The reference numbers used are from the document ExQ2

4.1 the applicant recites the Holford rule 3 - where possible choose inconspicuous locations for angle towers, terminal towers and sealing end compounds. Options 1 and 2 put forward both do this but option 2 is more compliant than option 1. It is agreed that option 2 has 2 more angle towers than the NG proposal however one of them is in the sealing end compound and the other one is only a very slight angle. Both of which are in inconspicuous locations and only really seen by the landowner. The decision to proceed with their proposal is as already stated an economic one which NG as pointed out at the hearing are bound to take but the economic effect on the landowner must have some effect on the decision making process.

Plan View 4
Low Loaders passing
Scale 1:200

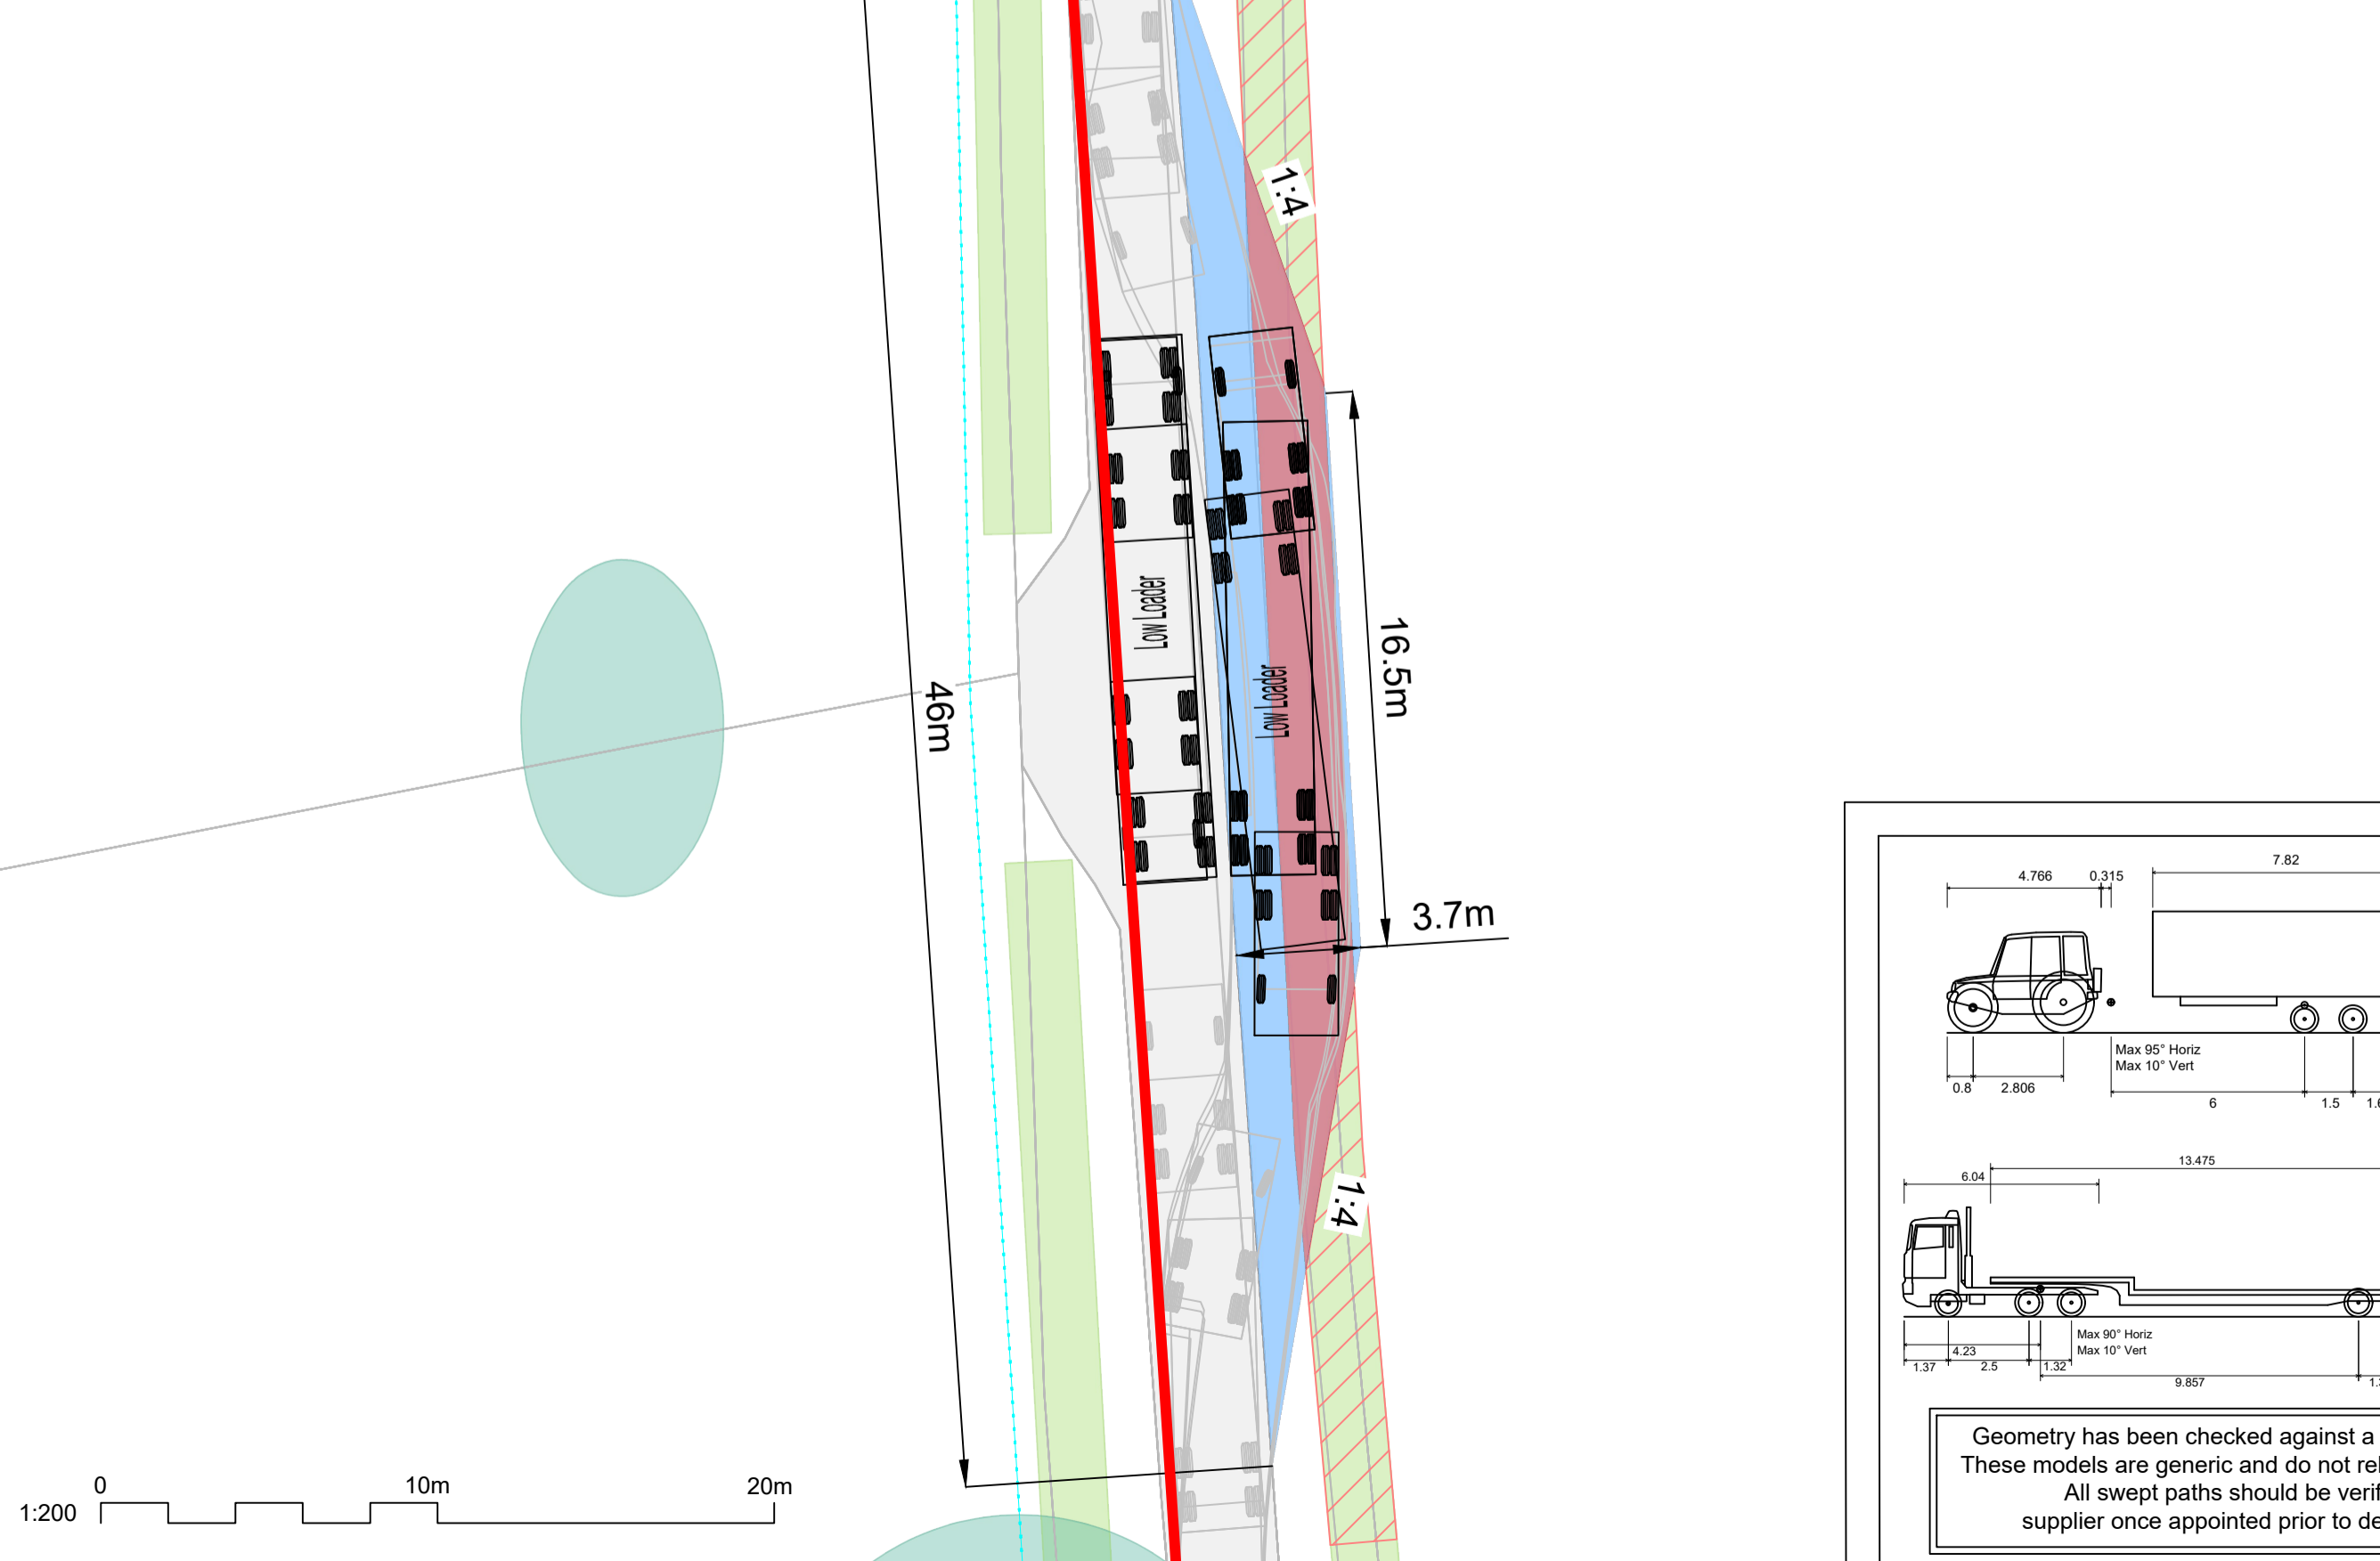
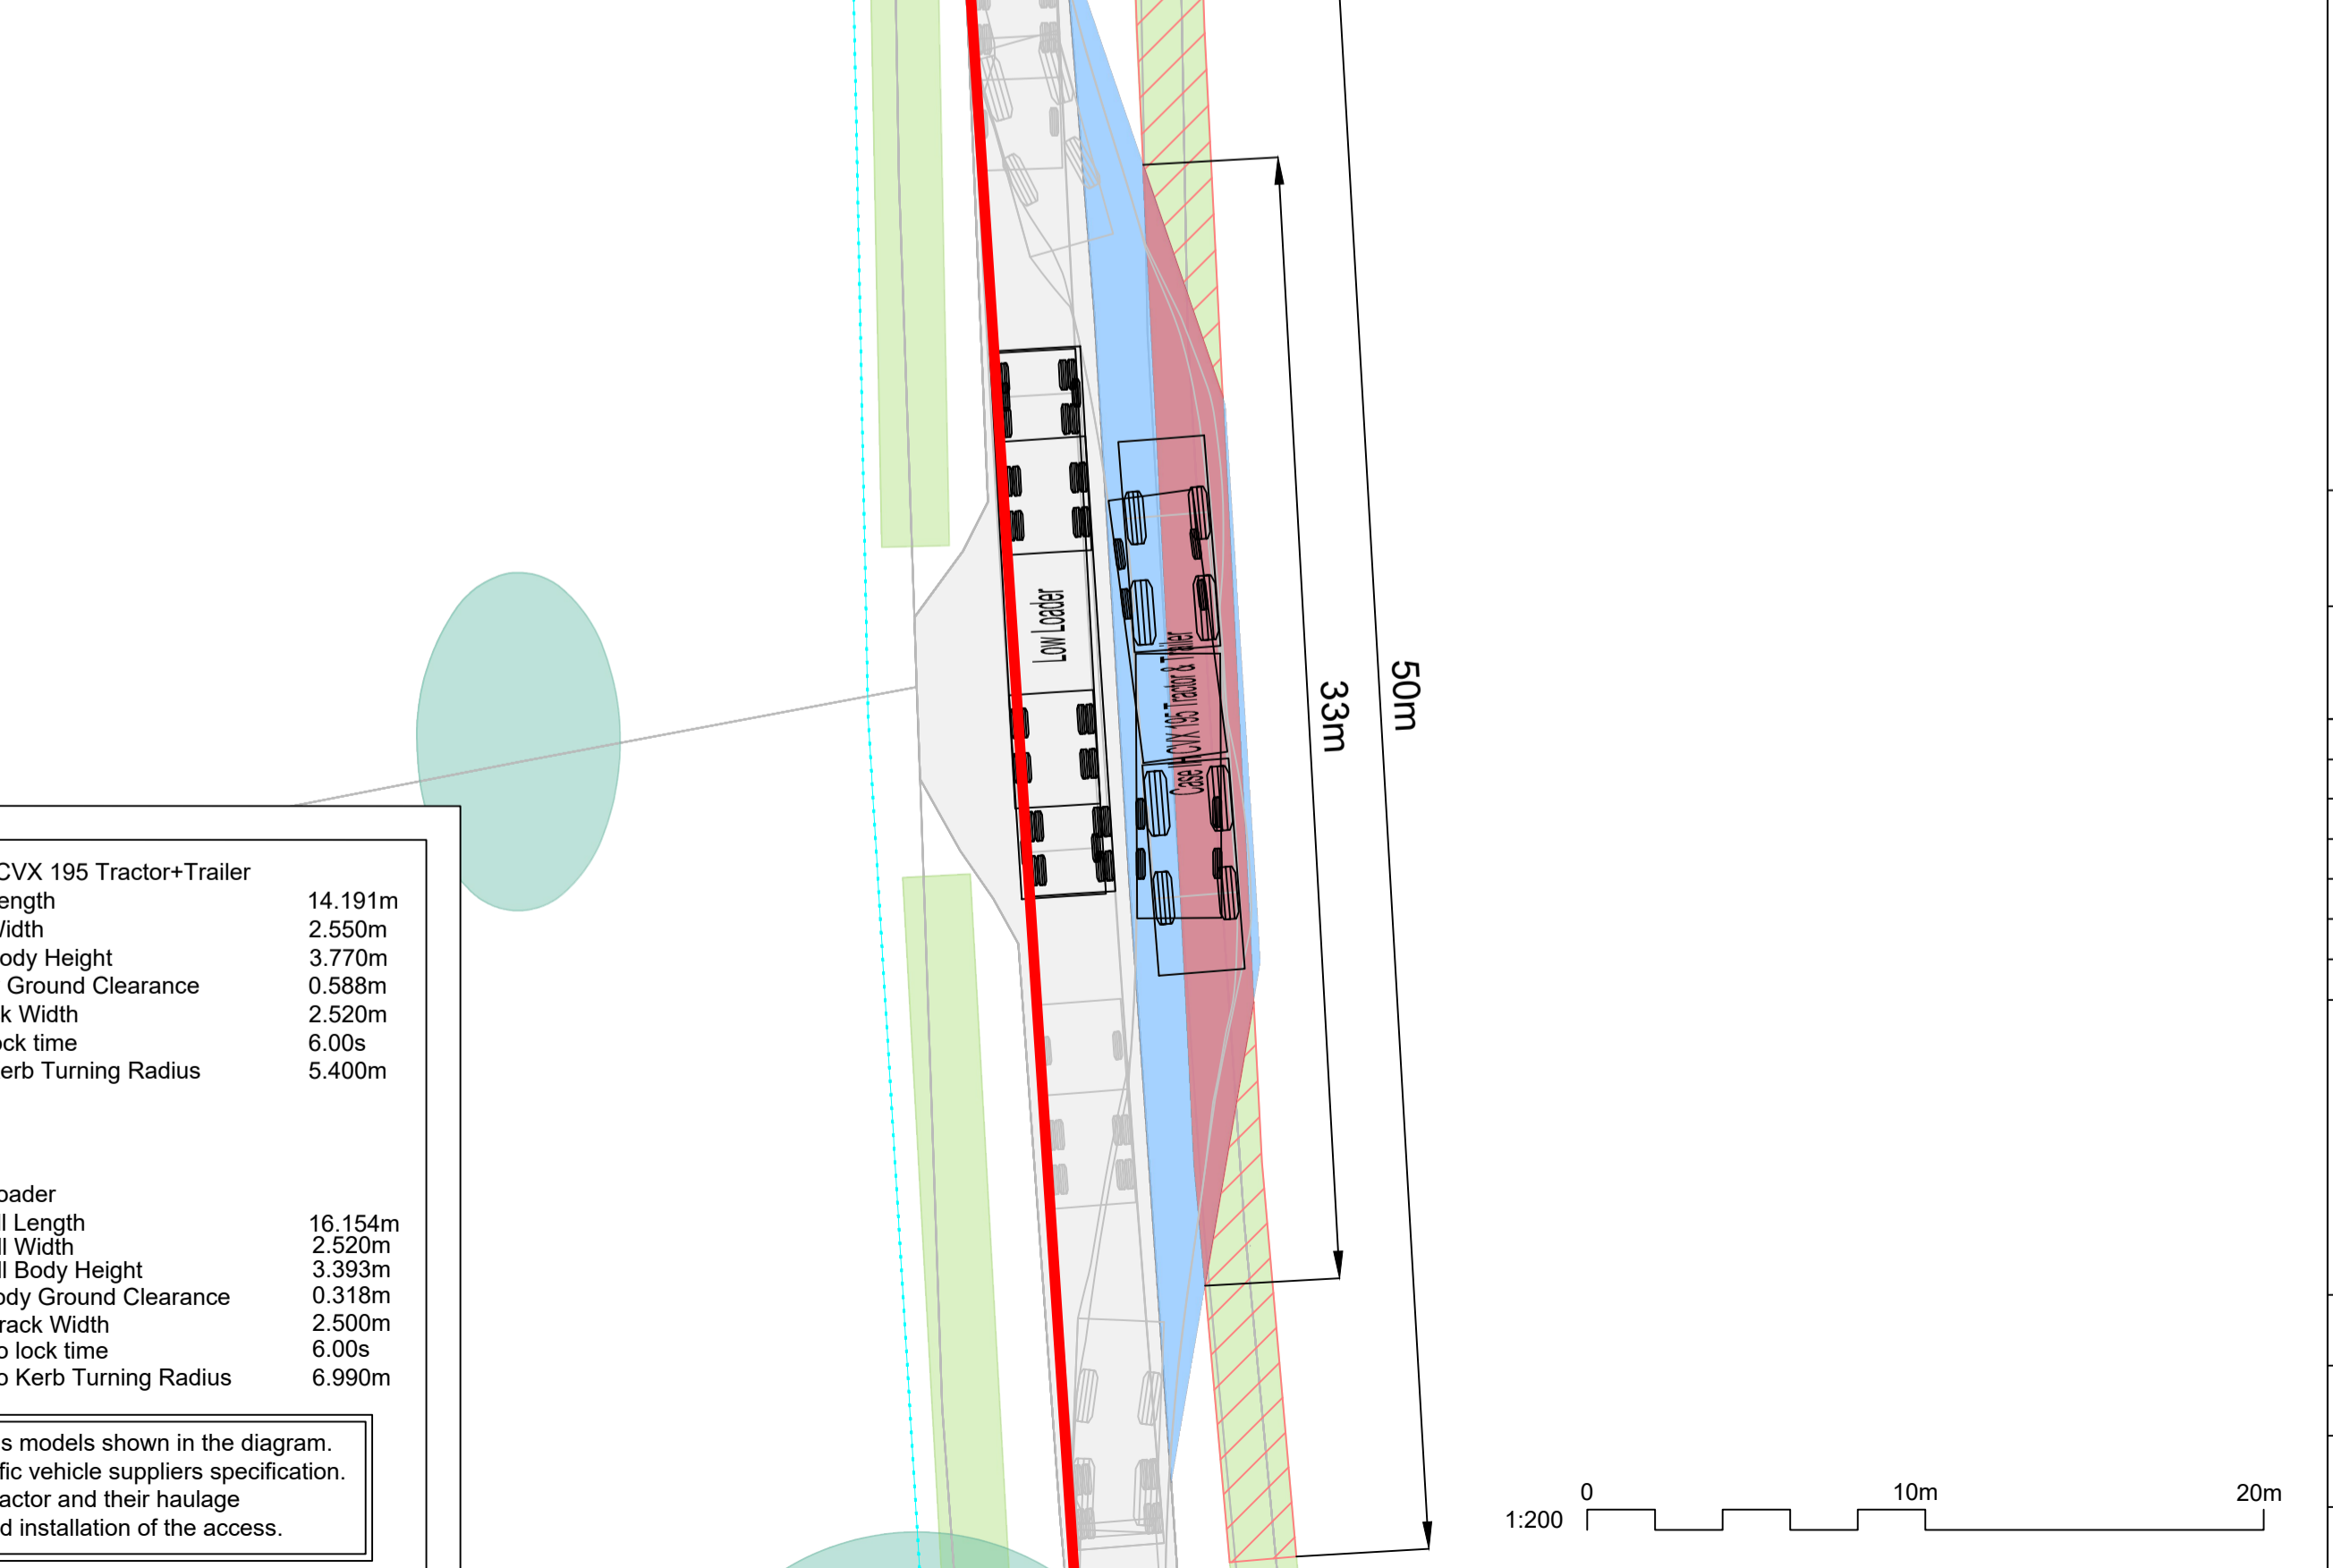
discussions are on going between the parties in the light of the proposed change to the permanent access route to the sealing end compounds. However the proposed location of the 2 passing places on Newlands Lane was received from NG last week - this propose to remove in total 100m of strong mature thorn hedge which is circa 7-8 feet tall, there has been no proposal put forward as to how the construction traffic will be managed. On boundary between the 2 compounds there is a dead oak tree and with some crown pruning an gap can be made in this location to allow construction traffic to pass unhindered and safely through to the sealing end compounds. This is a matter for further discussion with NG.
